## Comments on the Applicant's D2 Submissions

This document sets out the comments by Cambridgeshire County Council (**CCC**) on the Applicant's Deadline 1 (**D1**) submission, Applicant's Responses to the Examining Authority's Written Questions [REP1-079]. The table below provides the relevant paragraph or reference numbers.

### 8.3 Applicant's Responses to the Examining Authority's Written Questions [REP1-079]

Drawing Number
102375-MMD-01-XX-DR-C-DRAFT

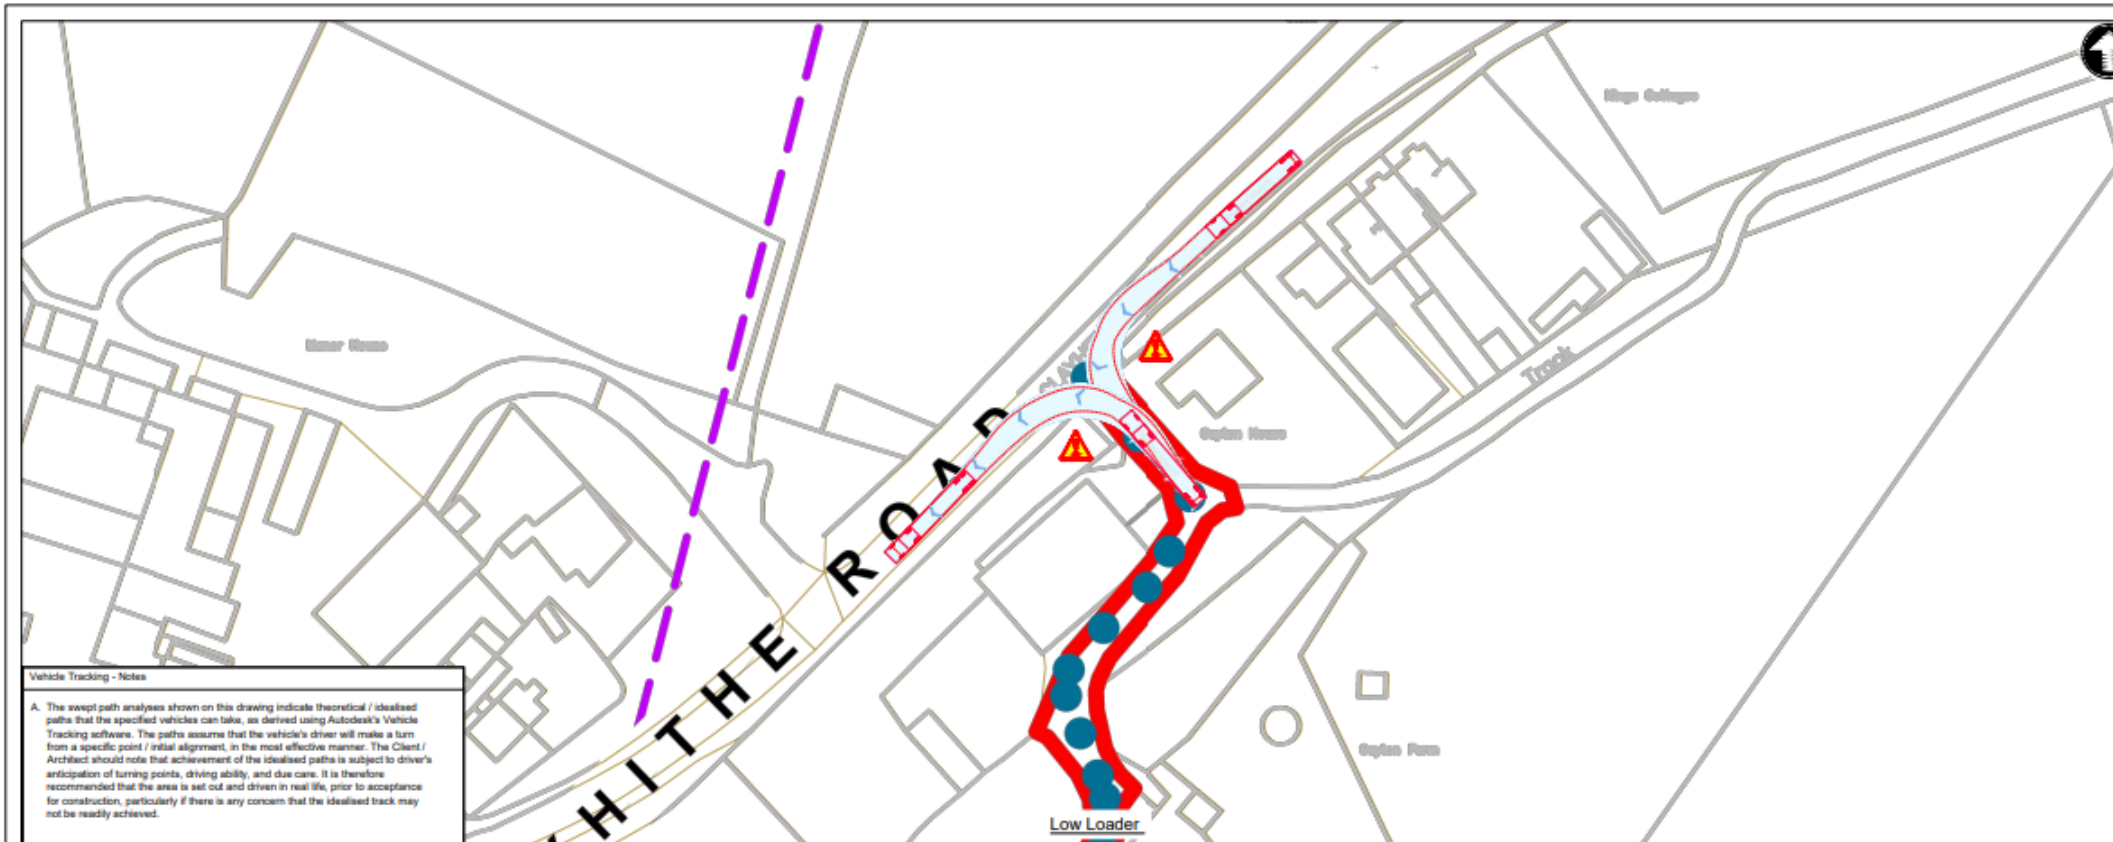
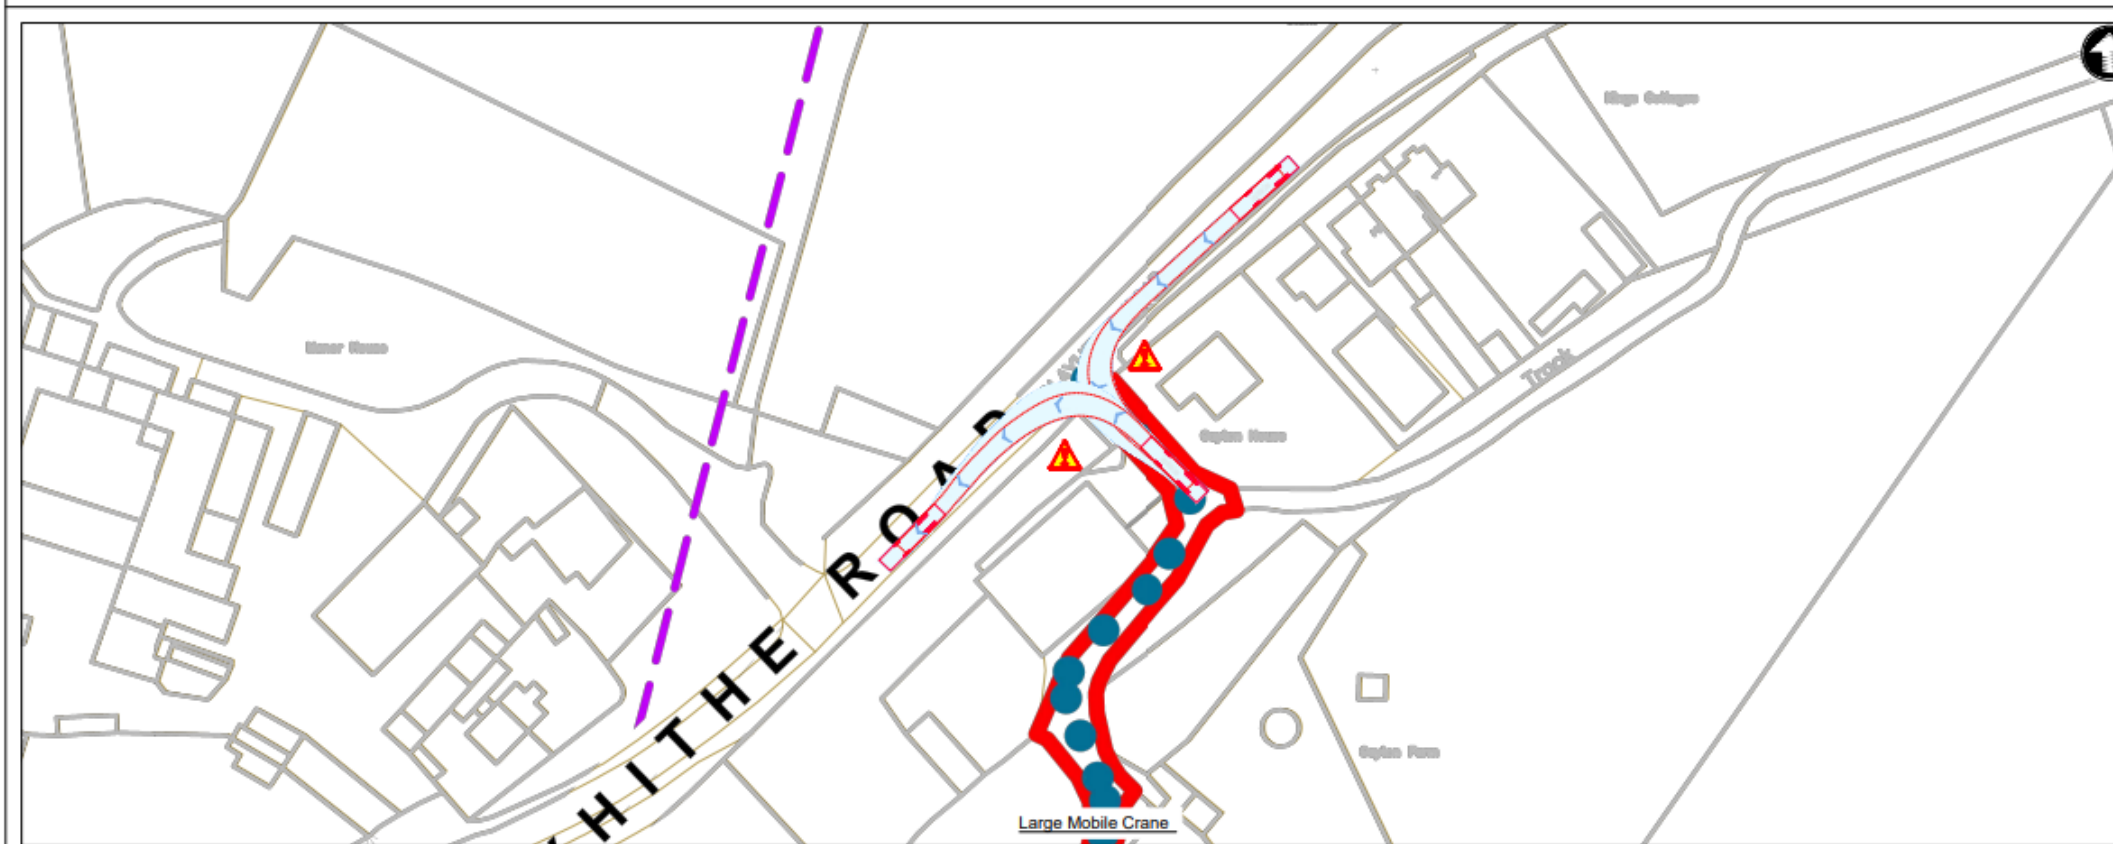
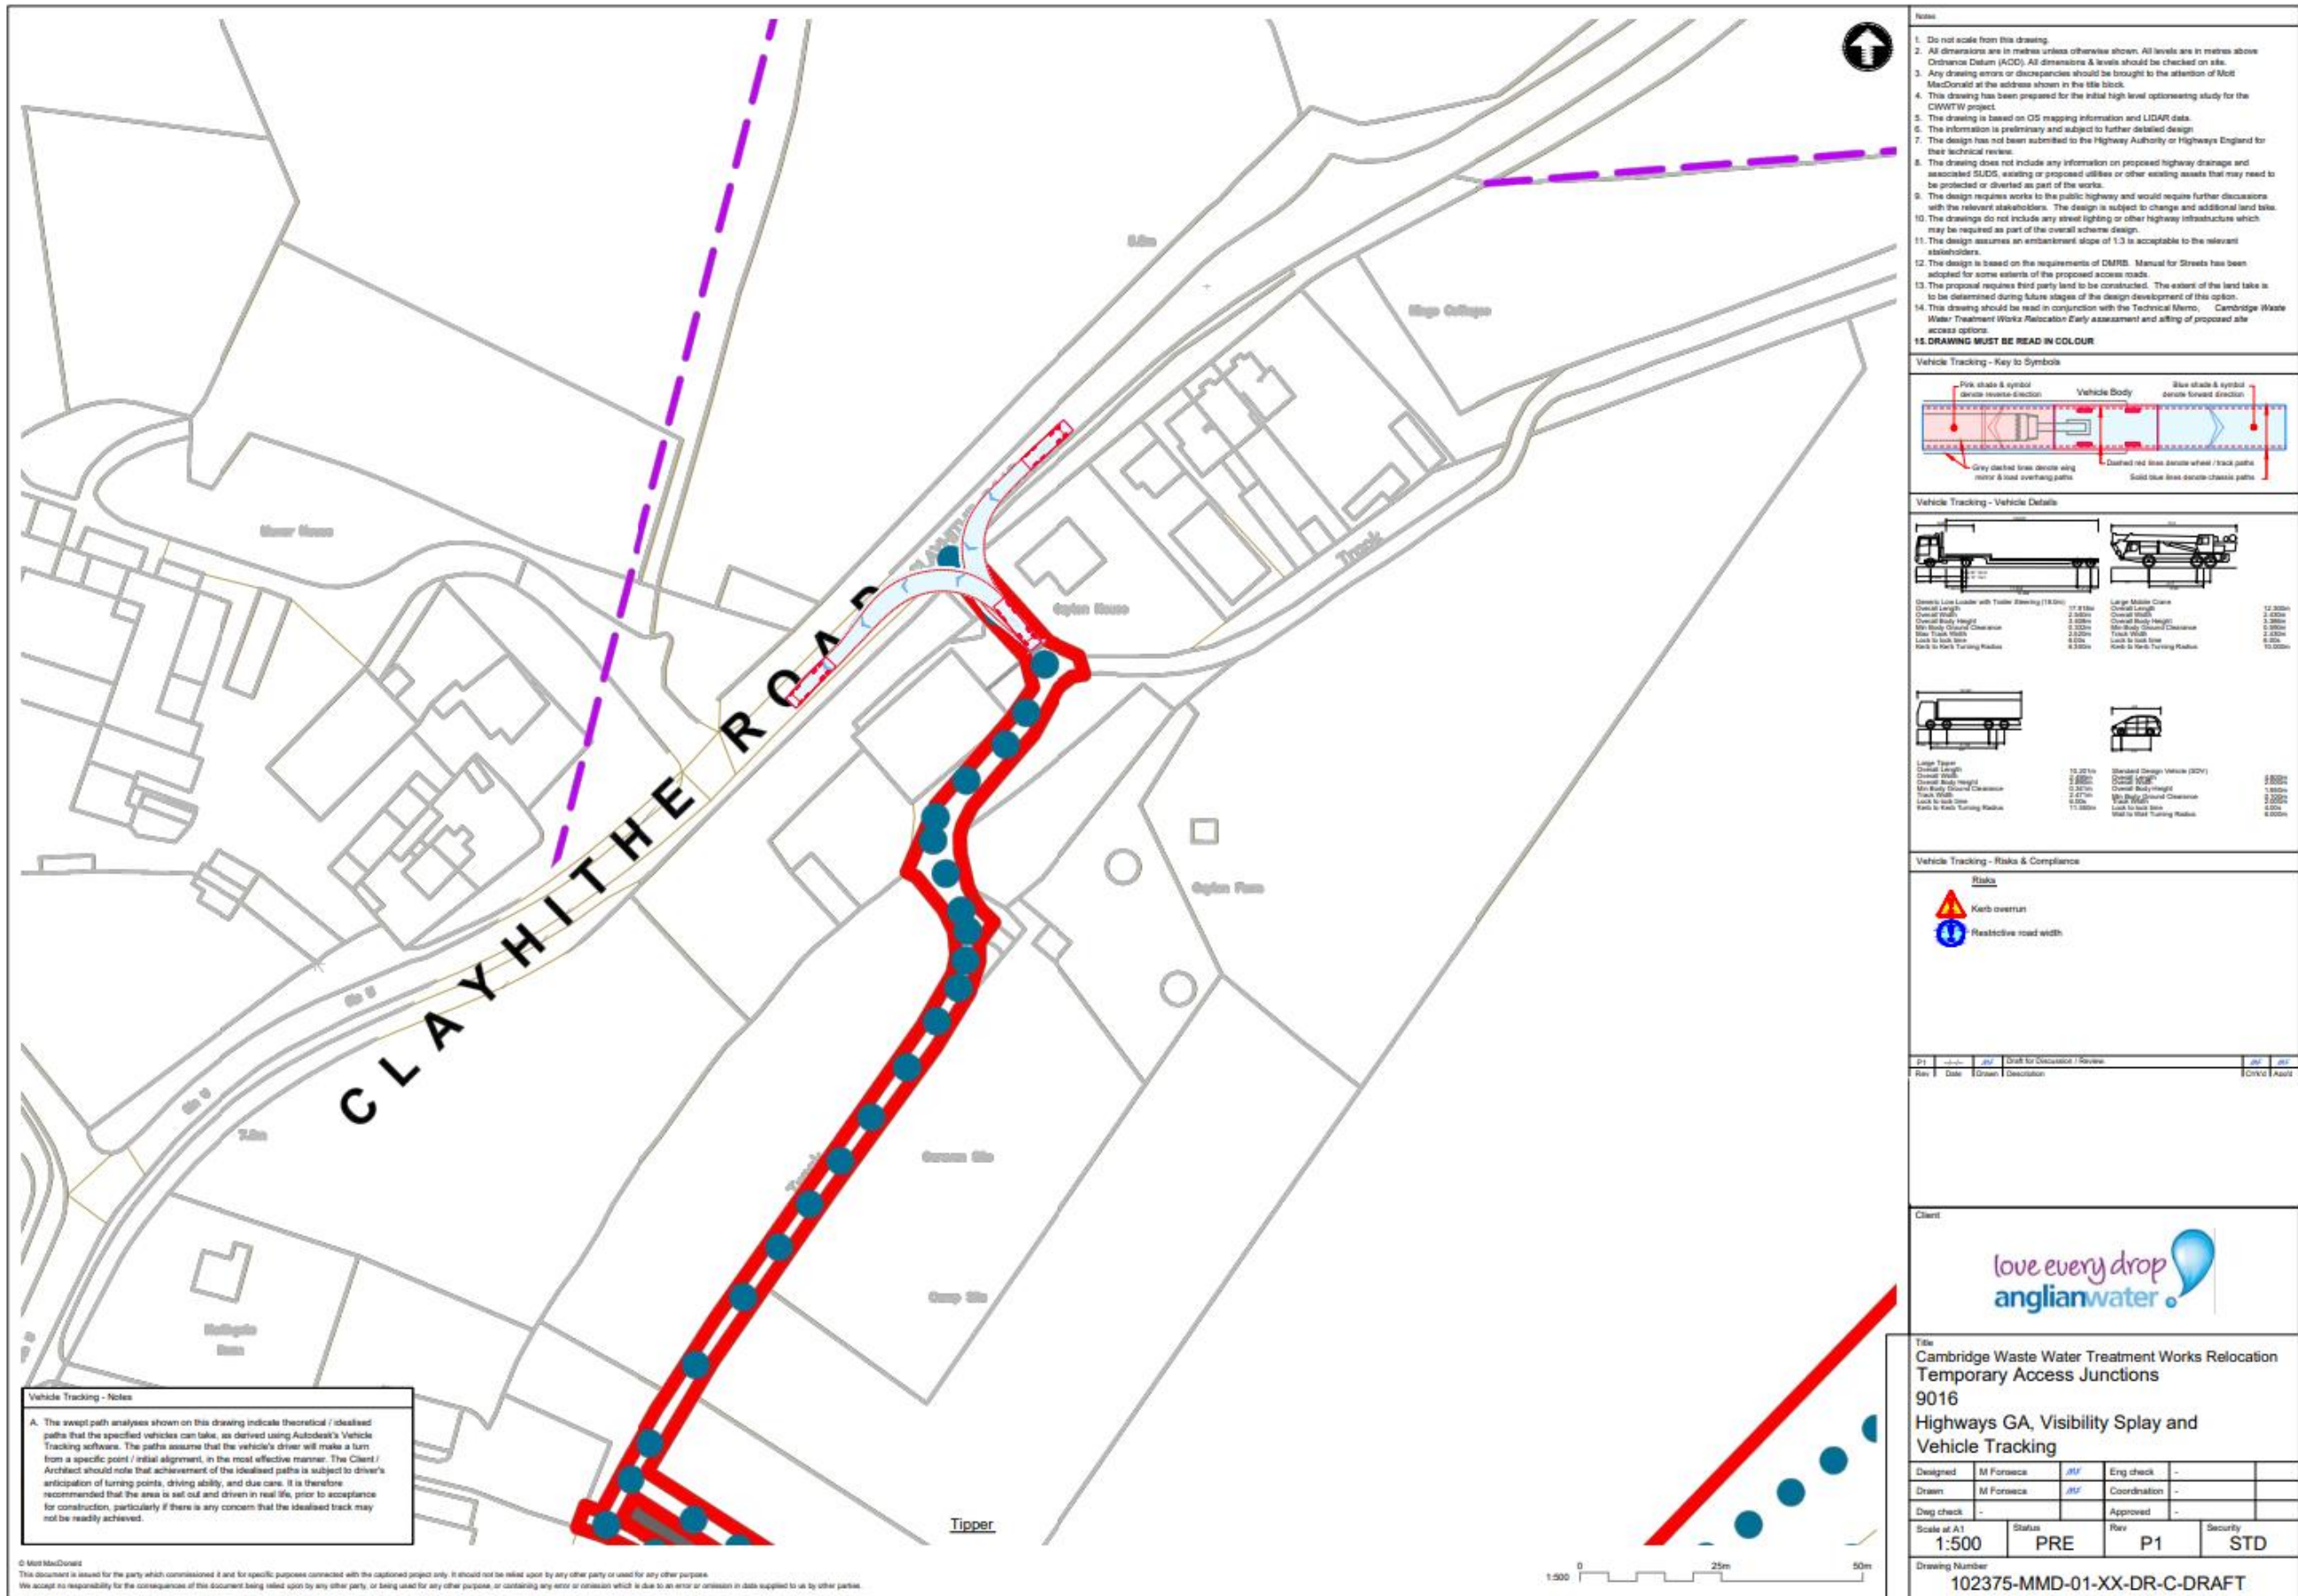
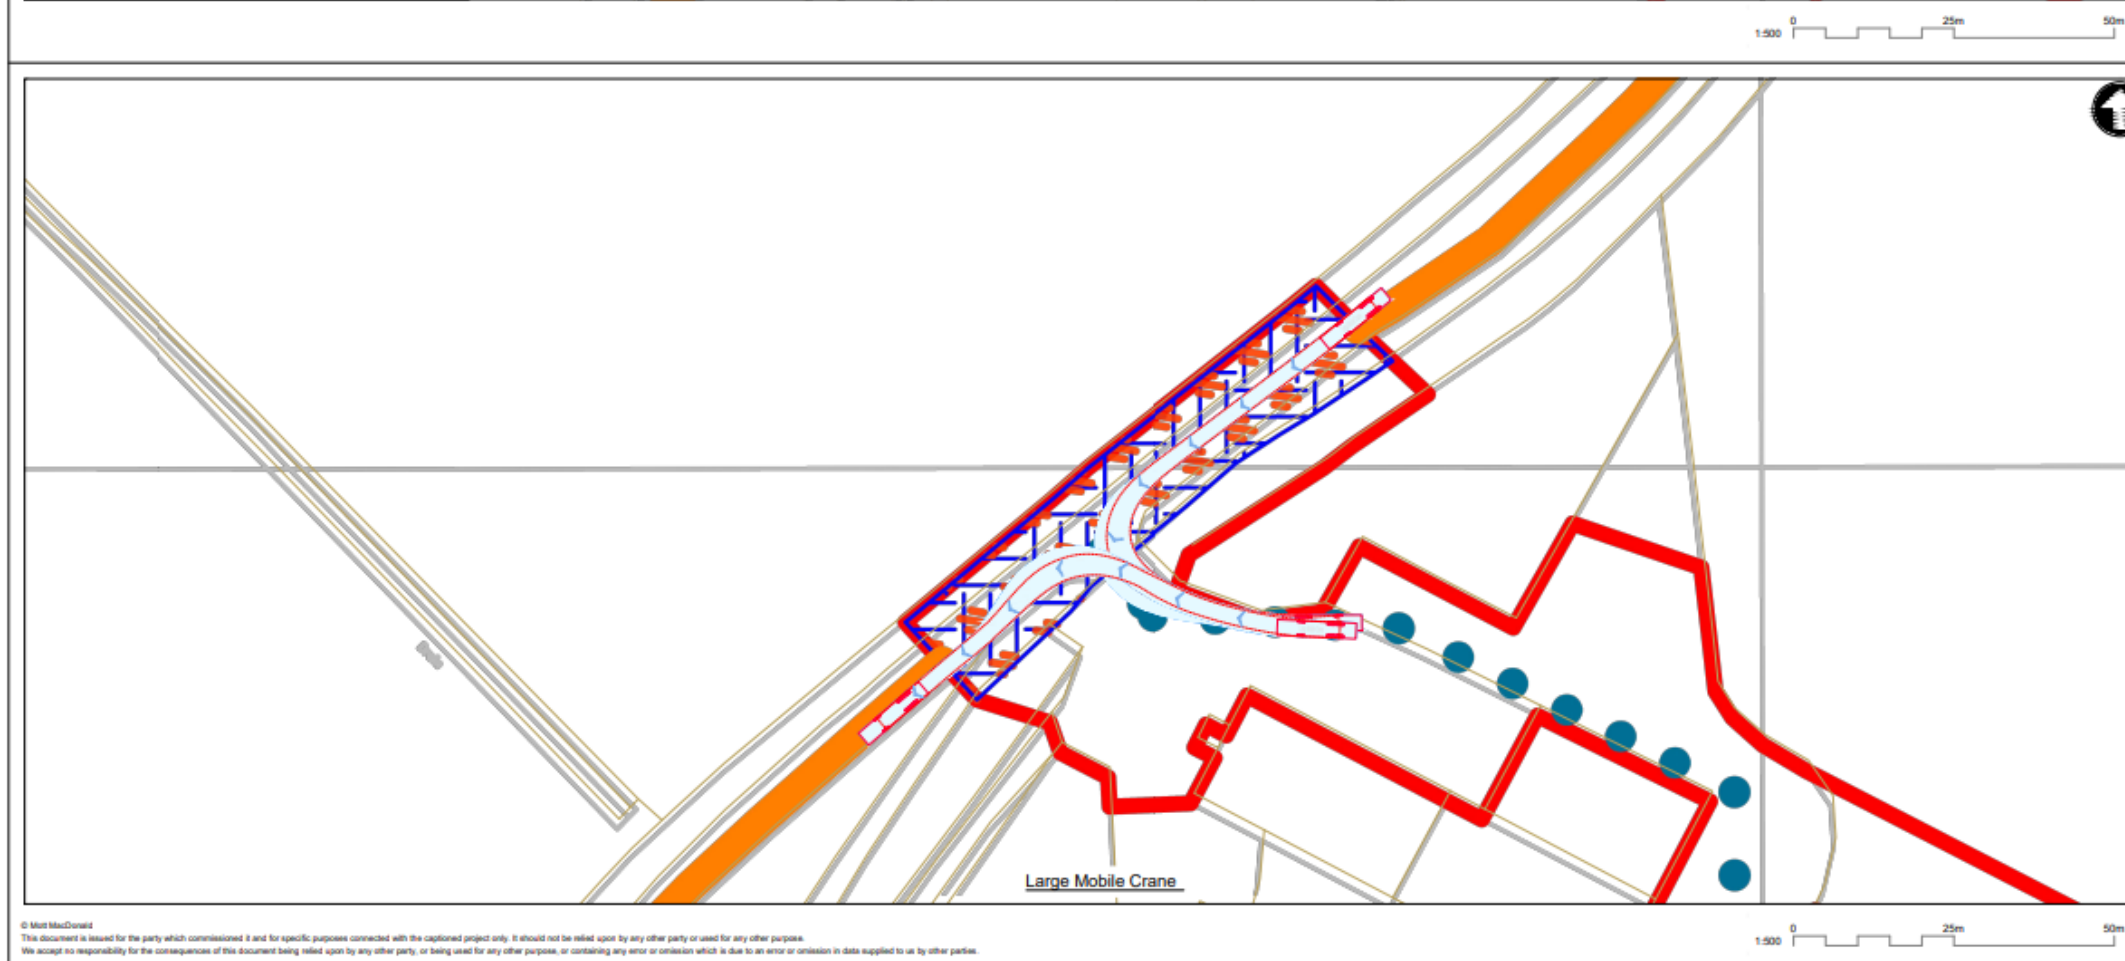
<p>of HGV traffic through the settlements of Horningsea and Fen Ditton. This requirement is recognised in the Construction Traffic Management Plan (CTMP) (App Doc Ref 5.4.19.7) [AS-109] and The Code of Construction Practice (CoCP) Part A (App Doc Ref 5.4.2.1) [APP-068]. The CTMP [AS-109], Section 4 'Access and Route Strategy' provides details on vehicle routing and Section 6.3 'Adherence to Designated Routes' outlines the measures in place for the adherence to designated routes. Furthermore, the CTMP (App Doc Ref 5.4.19.7) [AS-109] Paragraph 6.9.10 states the commitment to avoid routing HGV movements through Waterbeach during school drop-off and pick-up hours during term time.</p> <p>f) The Applicant took part of a Traffic Working Group (TWG) meeting on the 27 May 2021, held with CCoC and National Highways to discuss construction route options. CCoC noted at the meeting that the monitoring and enforcement of the construction routes would be a sensitive issue especially with regards to construction traffic at Waterbeach. The ES Chapter 19 (App Doc Ref 5.2.19) [AS-038], Table 1-4 outlines the matters discussed at TWGs between the Applicant and 222 ExQ1 Question to Question Response consultees. The Applicant has produced swept path drawings for the Hartridge's Lane / Clayhithe Road junction, available at Appendix G of the Transport Assessment Part 2 (App Doc Ref</p>

<p>5.4.19.3) [AS-108b] (drawing 102375-MMD-01-XX-DR-C-DRAFT) and shows a red boundary which represents the land that would be potentially required for the access of construction traffic. Additionally, the dDCO (App Doc Ref 2.1) [AS-139] Part 3 Requirement 10 grants the Applicant the powers to carry out street works on streets listed in Schedule 3 'Streets subjects to street works', which includes Hartridge's Lane.</p> <p>g) Applicant took part of a Traffic Working Group (TWG) meeting on the 27 May 2021, held with CCoC and National Highways to discuss construction route options. CCoC noted at the meeting that the monitoring and enforcement of the construction routes would be a sensitive issue especially with regards to construction traffic at Waterbeach. However, no issue was raised specific to Bannold Road and Long Drove. The Applicant has responded to local residents to confirm Long Drove would remain open to residents to pass throughout the work, as would Bannold Drove. The Applicant has produced swept path drawings for Bannold Road (drawing title 'temporary access junction COA14') and Long Drove (drawing title 'temporary access junction CA29'), available at Appendix G of the Transport Assessment Part 2 (App Doc Ref 5.4.19.3) [AS108b] which show that there would be no accessing the works site on Bannold Road and Long Drove but that there are restrictive road widths. Additionally, the dDCO (App Doc Ref 2.1) [AS-139] Part 3</p>
